From: Contact Centre (CRM) <contact@ribblevalley.gov.uk>
Sent: 13 May 2026 15:53
To: Planning
Subject: Planning Application Comments - 3/2025/0922 FS-Case-837532235

Planning Application Reference No.: 3/2025/0922

Address of Development: Land adjacent Tithe Barn Cottages Pendleton Road Wiswell BB7 9BZ

EXISTING GROUND FLOOR PLAN, EXISTING & PROPOSED CROSS SECTION DETAILS AND EXISTING & PROPOSED ELEVATIONS, PROPOSED AND EXISTING SITE PLAN.

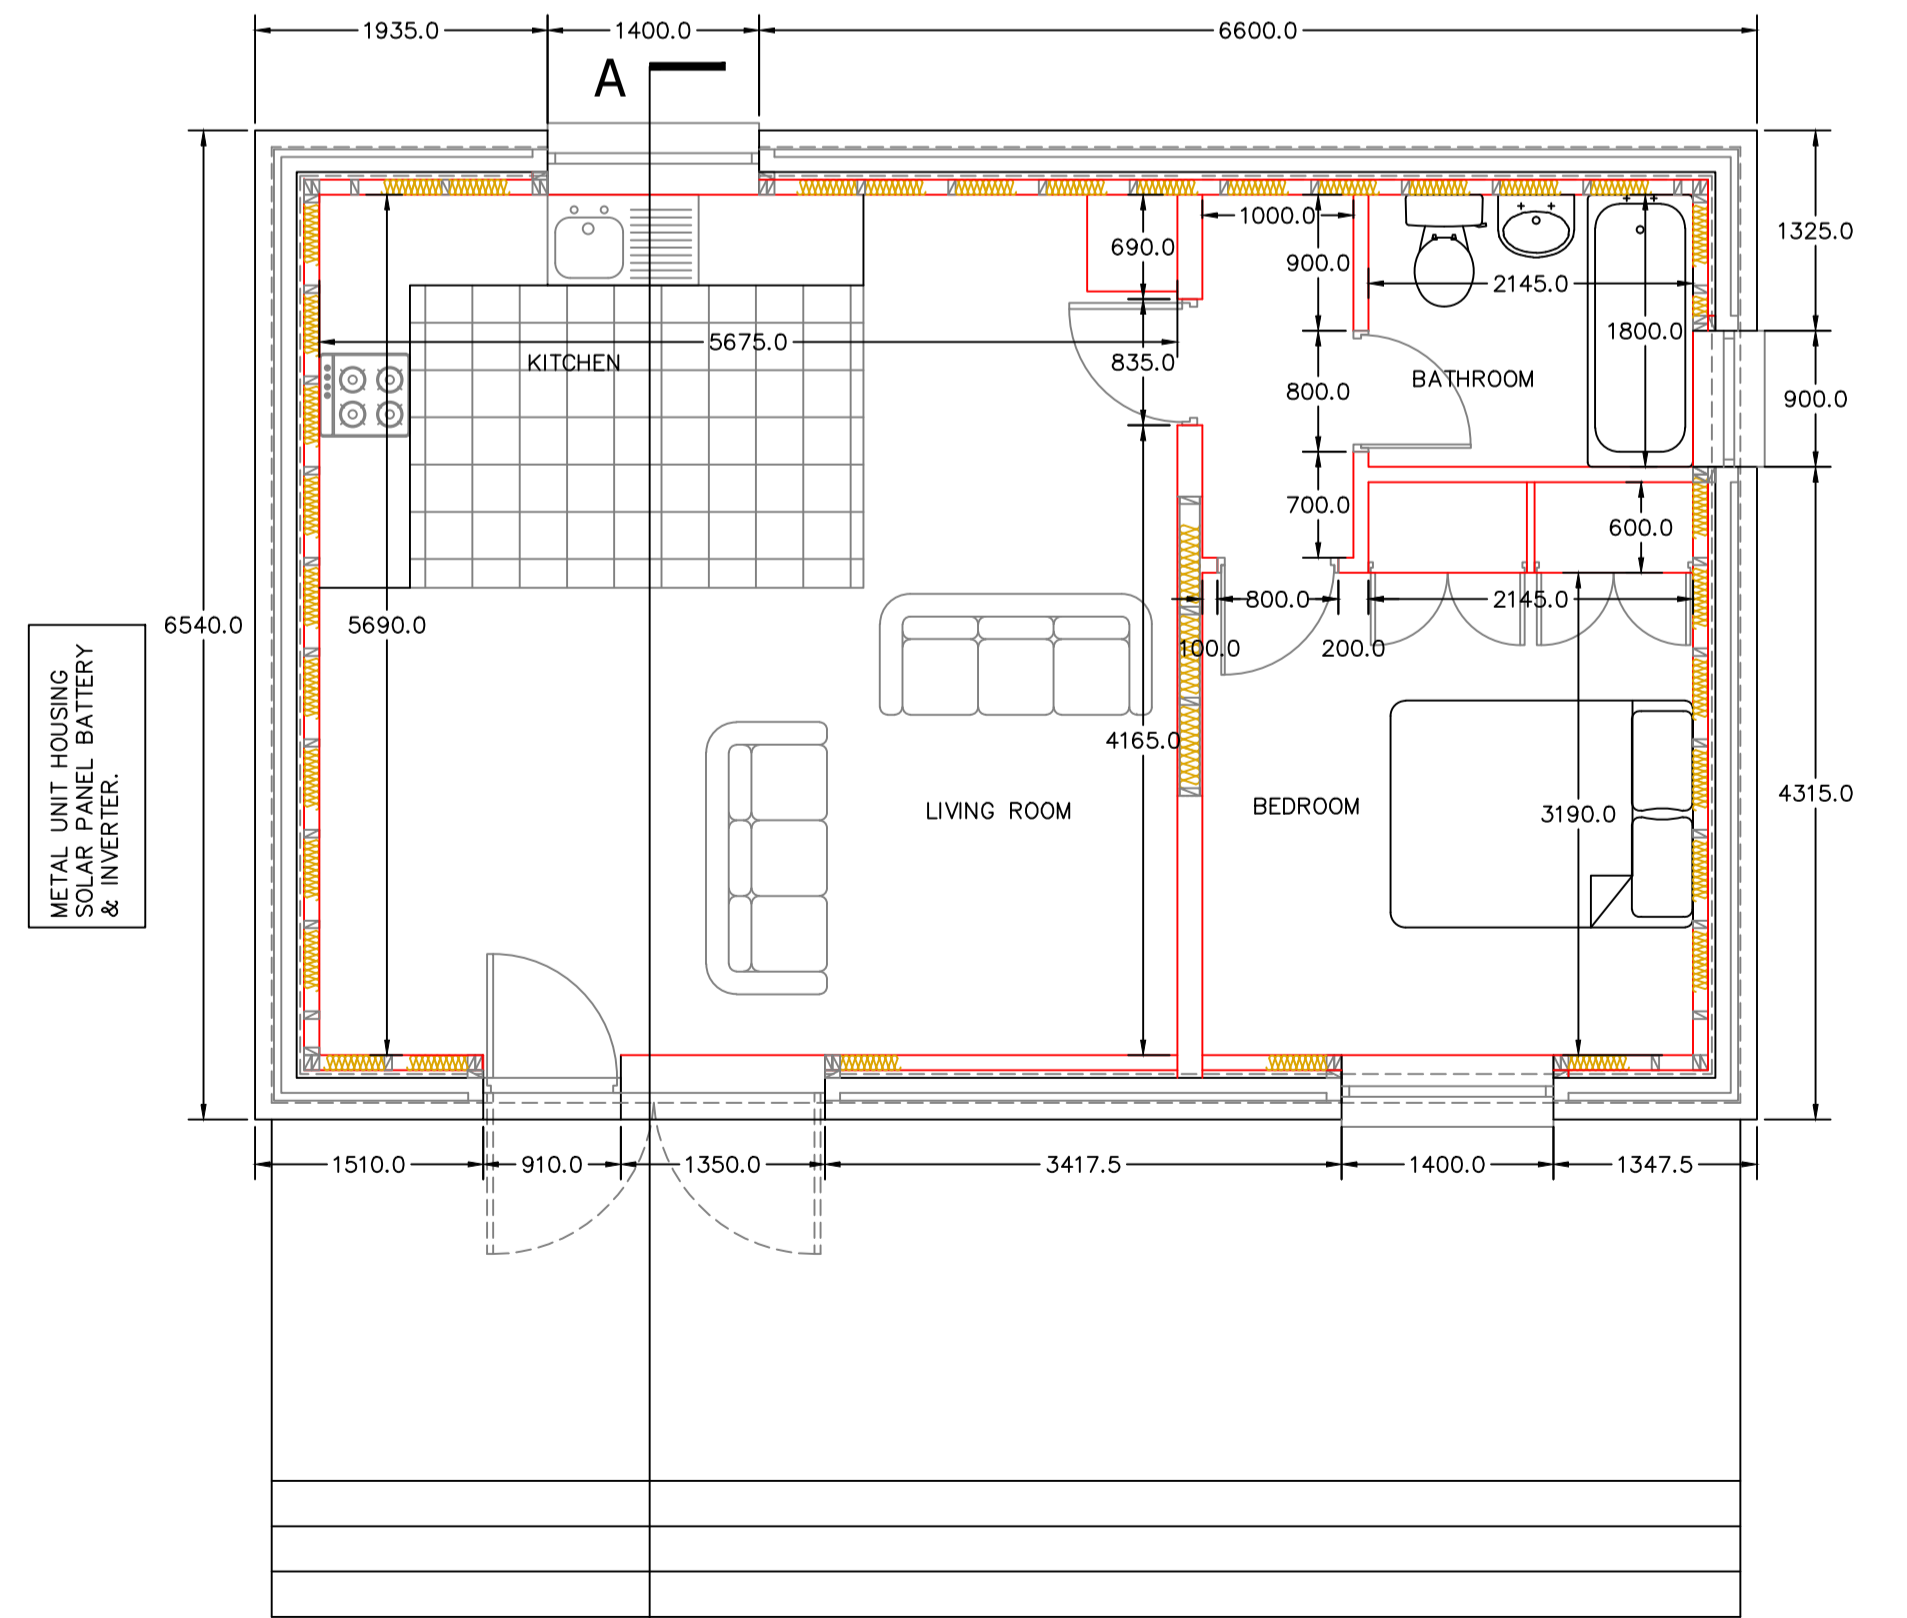
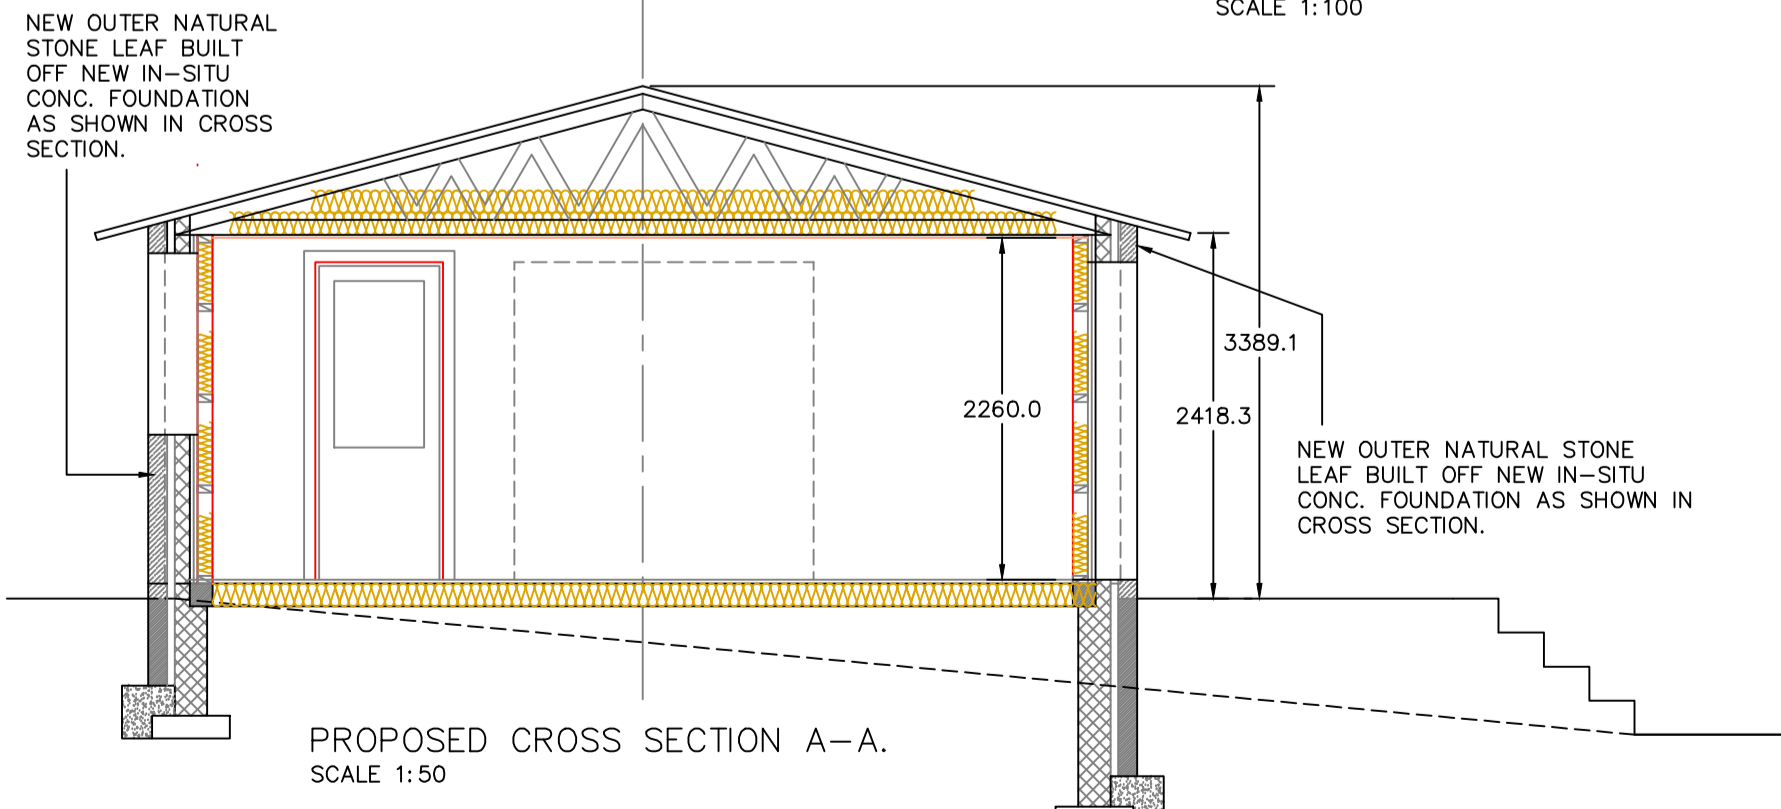
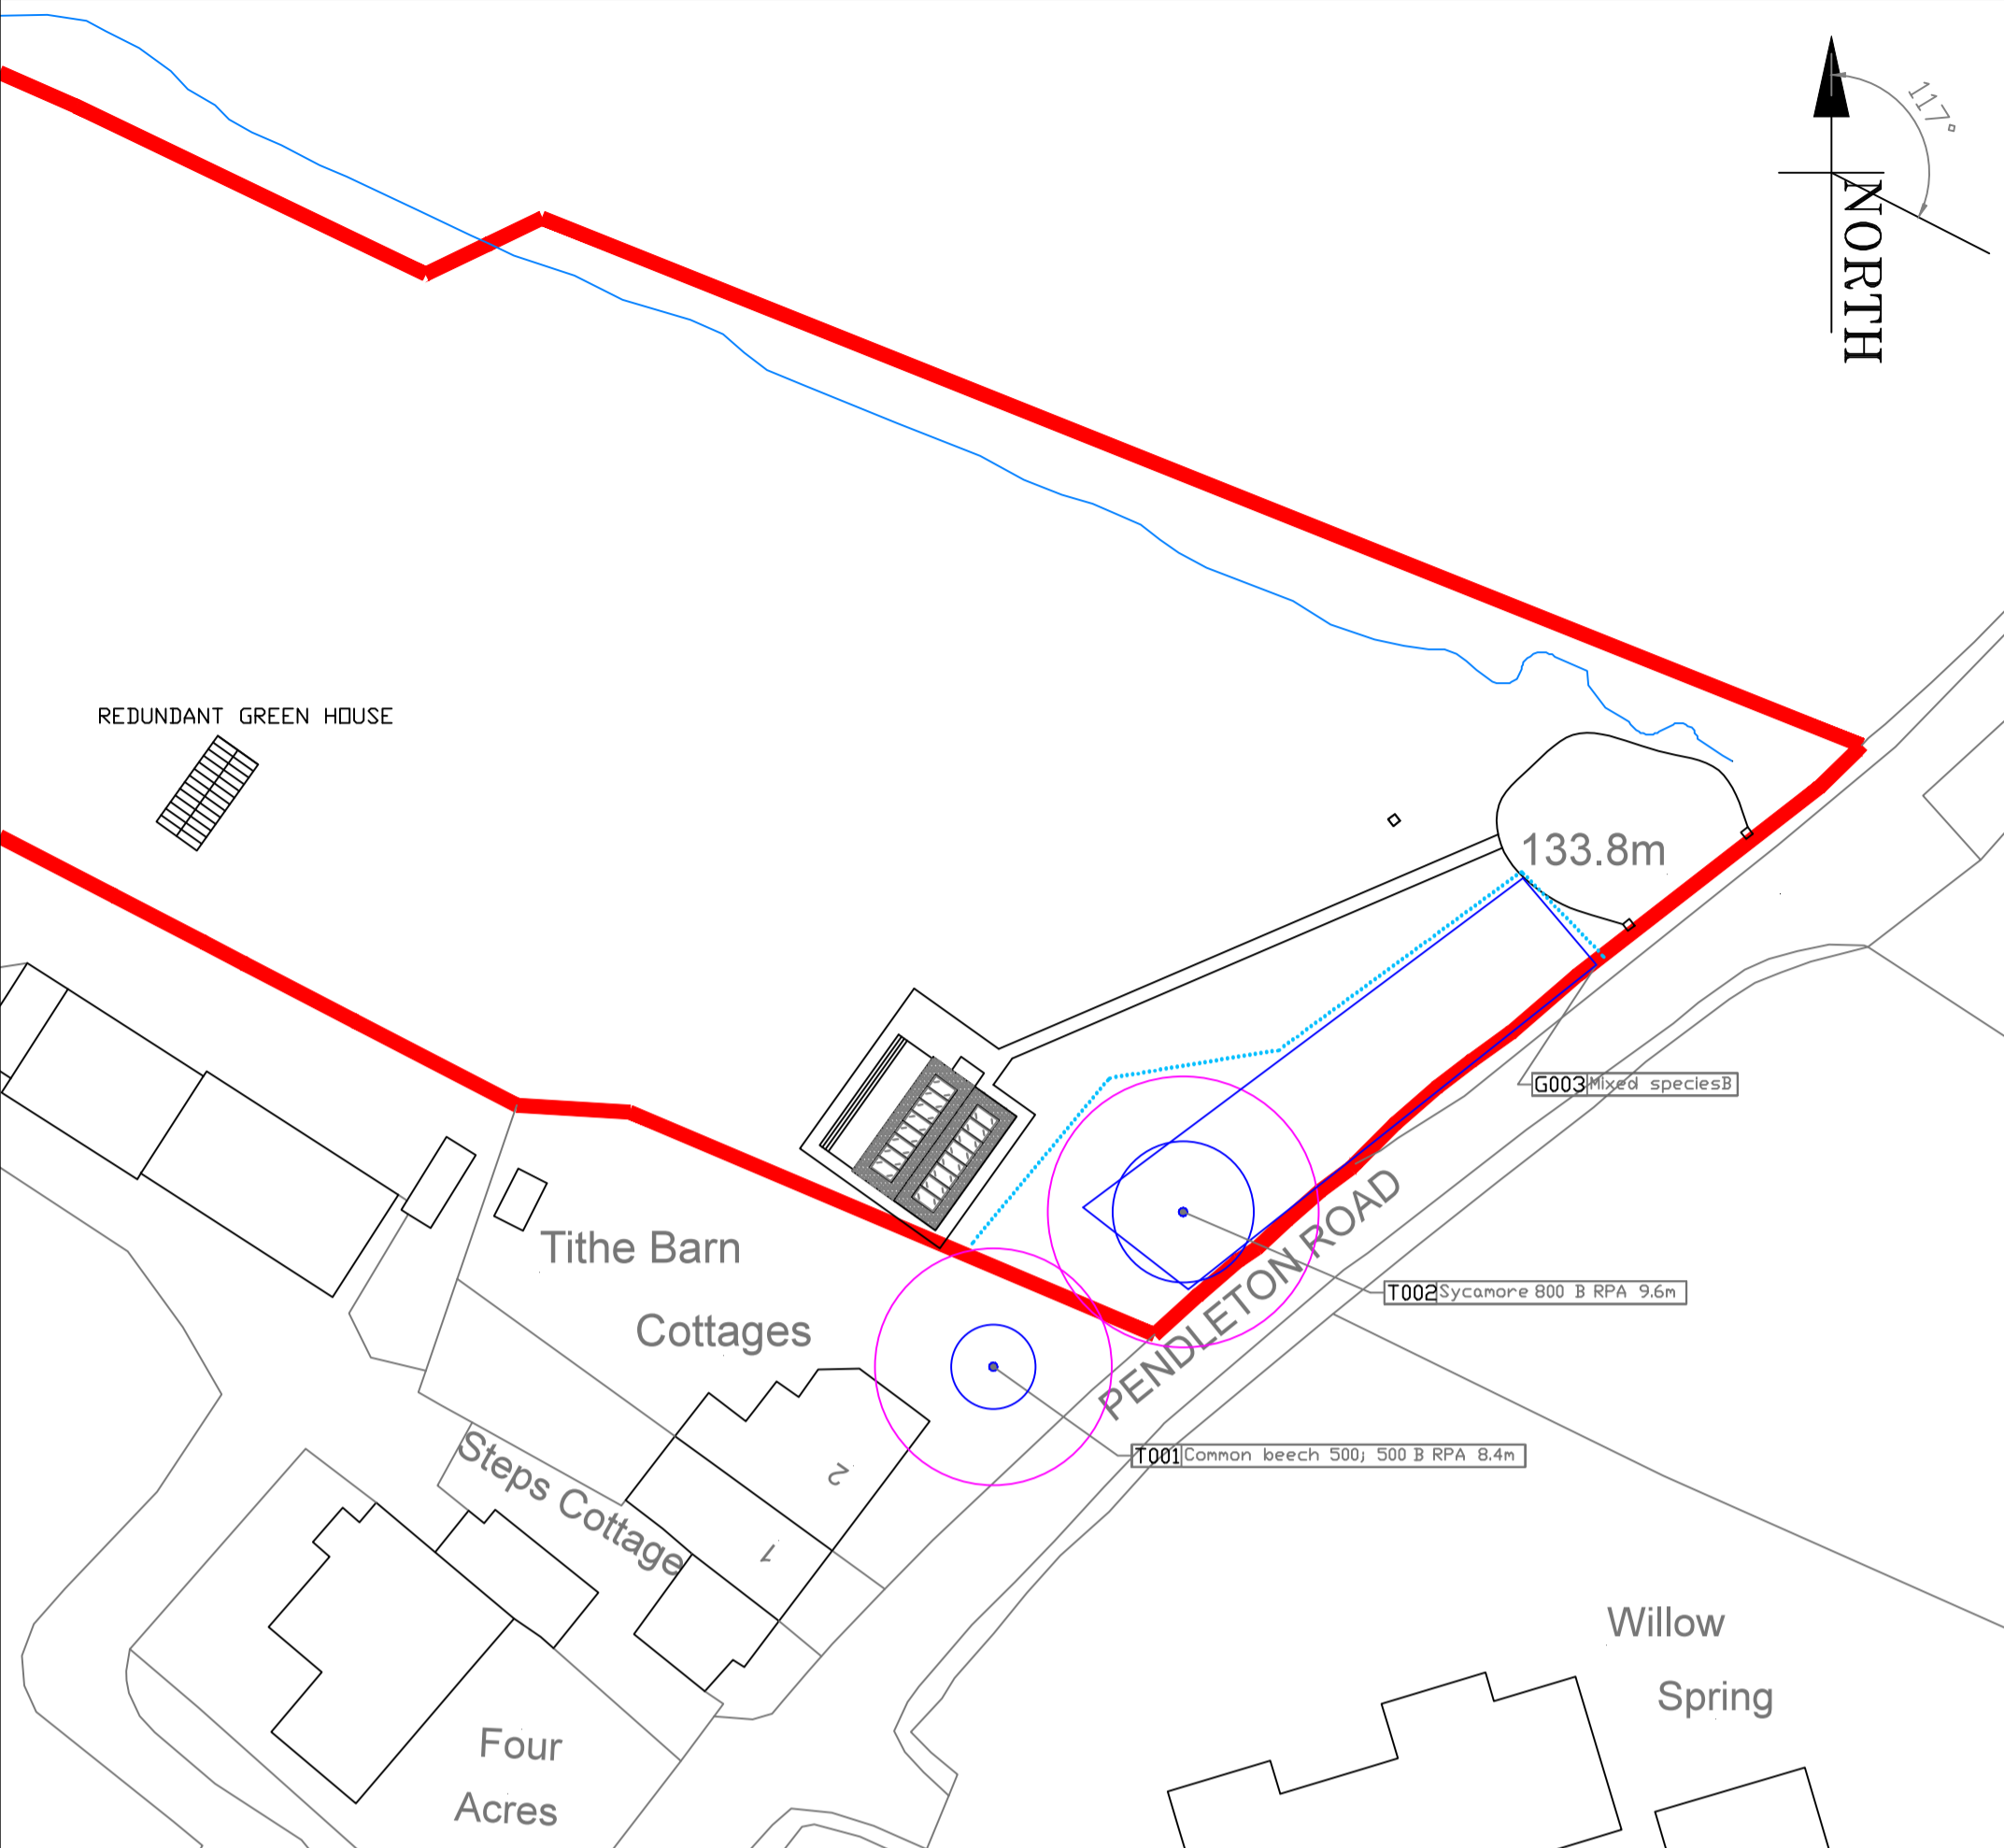
I am also highly sceptical that the existing wooden shed could structurally support the extent of works proposed, including a tiled roof and a full solar panel array, without substantial rebuilding and reinforcement. This calls into question whether this can genuinely be described as a "conversion" at all. In reality, the proposal appears far closer to the construction of a new dwelling under the guise of converting an existing structure.

The original planning application for this was rejected and these new plans don't offer any substantial changes therefore all of the original objections remain the same. There are only 3 small points of change that I can see. One is to add a window, another is to use stone on the building and the final one is to enter and exit the site in a forward movement. On the third point this is only possible due to the landowner previously having the grassed area replaced with hardcore. This harms the natural biodiversity of the land. In the transport statement it also mentions that visibility needs to be made greater. Their stated intention is to cut back the hedging alongside the lane. This changes the environment and appearance of the area.
